BOGNOR NORTHERN RELIEF ROAD, PHASE 1

“PROPOSED PLAYING FIELD ACCESS” (Version 2.0)

Road Safety Audit Combined Stage 1 & Stage 2 – Detailed Design

Designers’ Response- Glenn Tregillis May 2015

TITLE: SPORTS PITCH ACCESS PROPOSED DRAINAGE

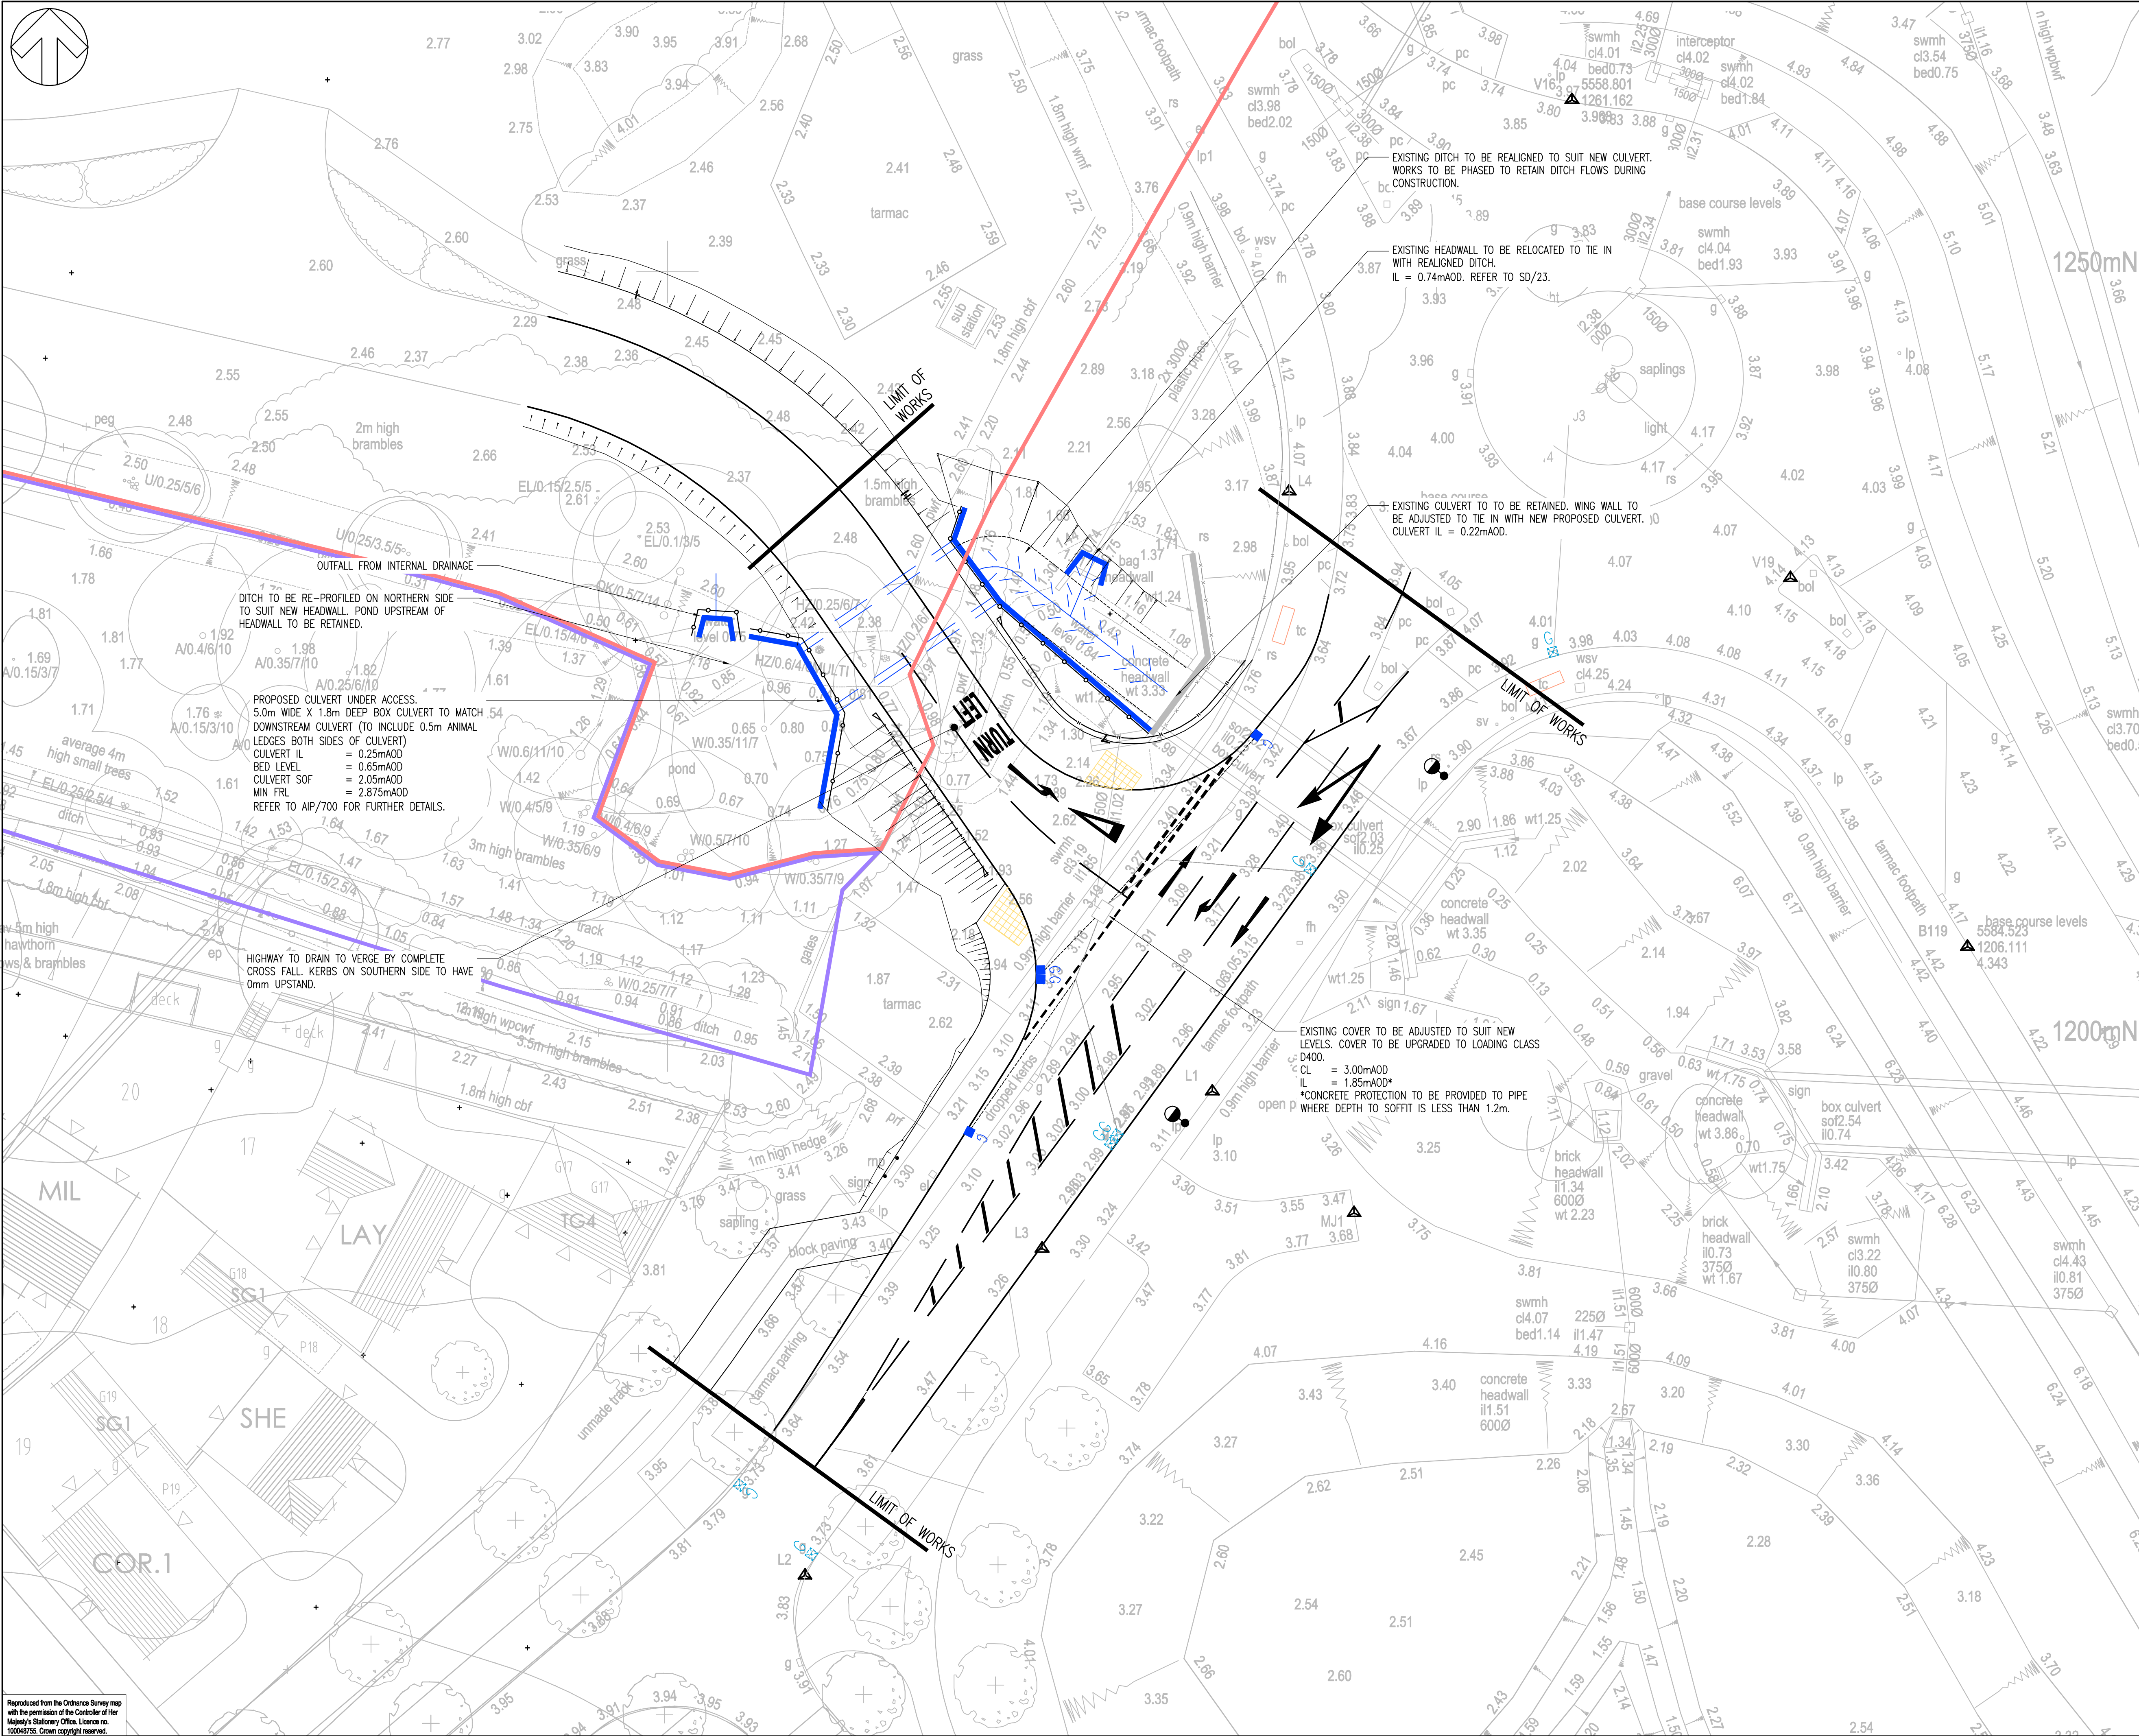
Location: Proposed Playing Fields Access Road, at the junction with Southern Arm of Stanover Lane Roundabout.

Summary: Risk of inadequate carriageway drainage.

The proposed access road appears to be located where the adjacent land is below the level of existing carriageway, but no gullies appear to be included within the design, especially at the proposed dropped kerb crossing points where pedestrians stepping into the carriageway to cross may need to step across flowing surface water or risk of crossing ponding which may give rise to hazardous conditions at times of icy weather.

The proposed Playing Field Access Road may need to be checked and appropriate gullies provided at the upstream side of the pedestrian dropped kerb crossing points.

The proposed access arrangements have been revisited with the inclusion of additional road gullies.

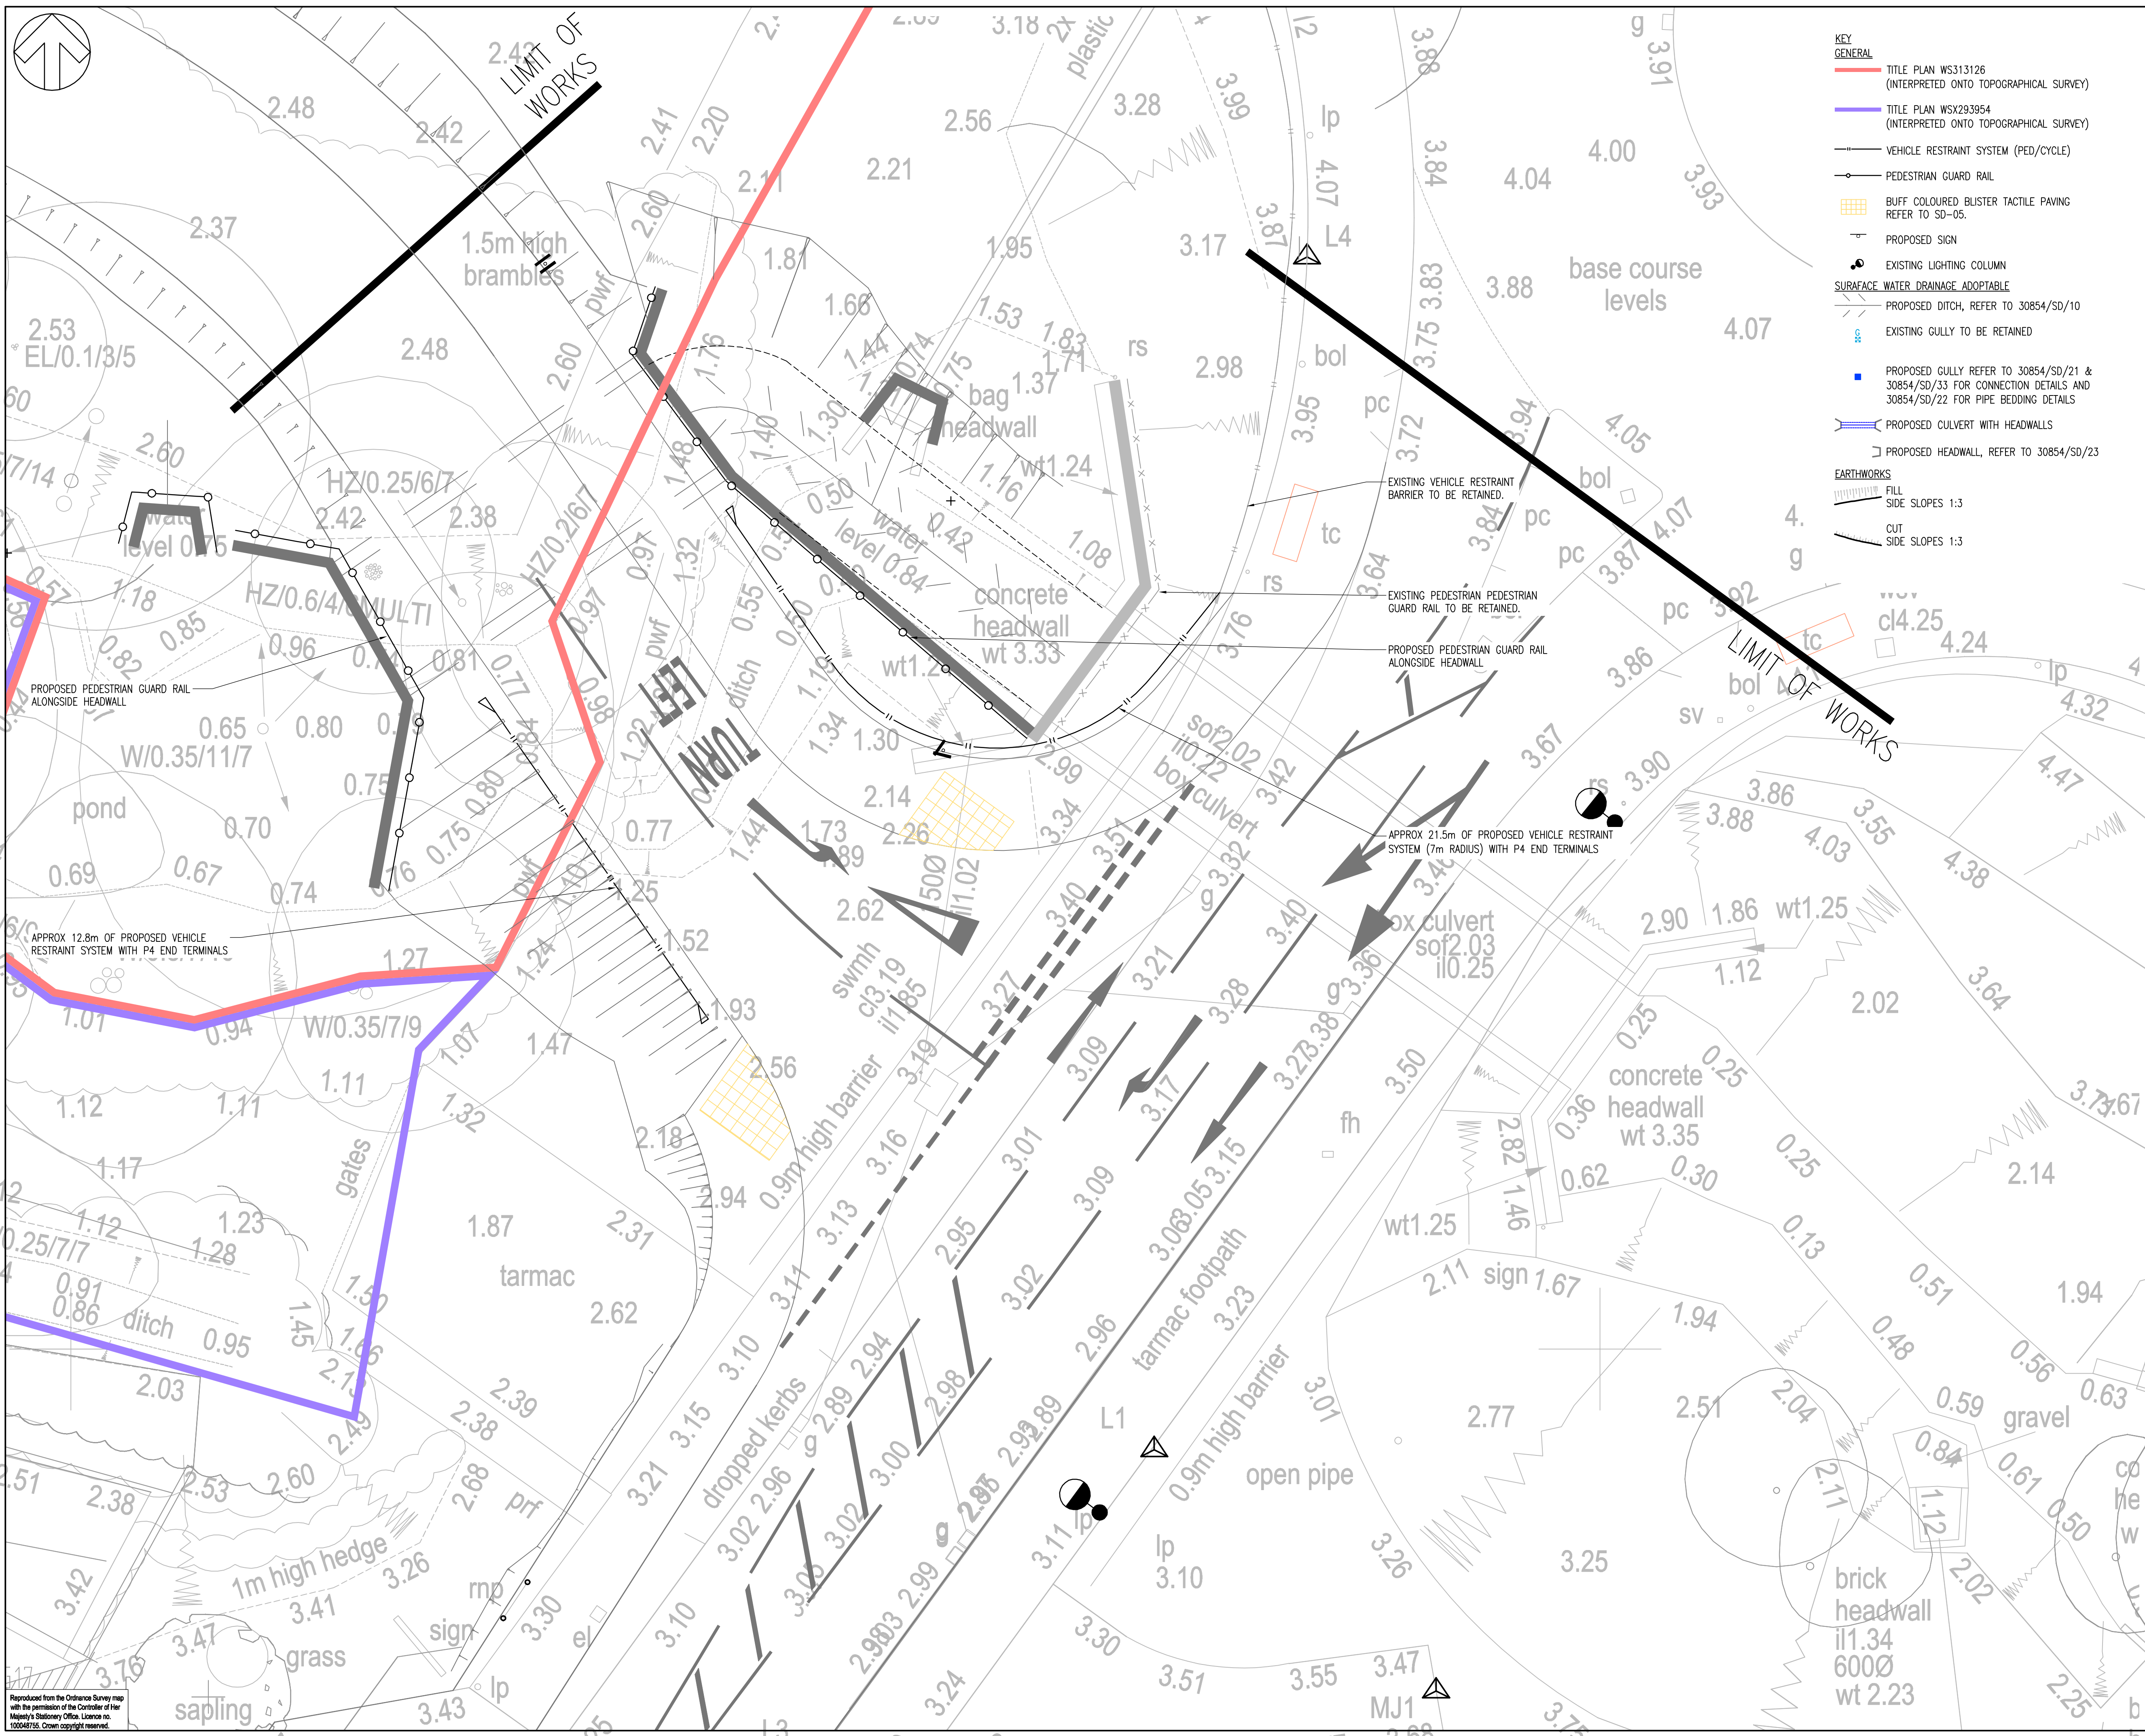
The proposed access arrangements should be revisited with a view to re-assessing the potential traffic flows at the junction and of sufficiently widening the carriageway locally to provide a segregated area at the centre of carriageway for right turning vehicle to move into and potentially wait for suitable gap if required to do so, whilst the current planting at the rear of the Vehicle Restraint System on the inner radius curvature should be removed.

There may also be scope to shift the safety barrier further back from the inner radius kerb line to thus improve forward visibility around the left turning curvature.

Vehicle Restraint System shall be altered to provide for the access.
